**Re: Final Plat Review for Proposed Subdivision of Tracts A and B, Montgomery Plaza**

Cartesian Surveys is acting as a co-agent with Modulus Architects for Montgomery Plaza Partners LLC and requests a final plat review to create two (2) new lots from two (2) existing lots for Tracts B-1 and B-2 of Montgomery Plaza at 4595 and 4601 San Mateo Blvd NE between Jefferson Ave NE and San Mateo Blvd NE. This plat will vacate two public easements, grant easements and adjust the lot line between the two existing lots. The property is currently zoned as MX-M. The plat was last heard for final plat review on July 21, 2021 under project number PR-2020-004640. The comments from that hearing are addressed below:

Detail "B" for Easement [37]

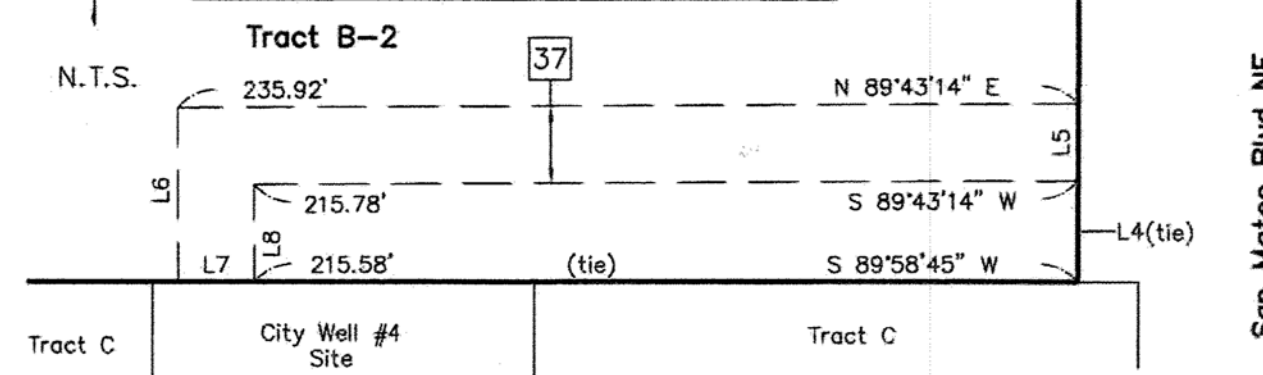
1. No objections.
2. PREVIOUS COMMENT: This plat shows Tract C, which is listed as “Not a Part”. However, easement 32, which is to be vacated, is also listed on this tract. Can the applicant clarify the extent of the vacation in the documents or for the record?

**Tract 1-C is no longer a part of this platting action as well as Tract C. Easement 32 will be vacated within the proposed Tracts B-1 and B-2 only. A new access easement to the well site is being granted in it's place (Easement numbered 37)**
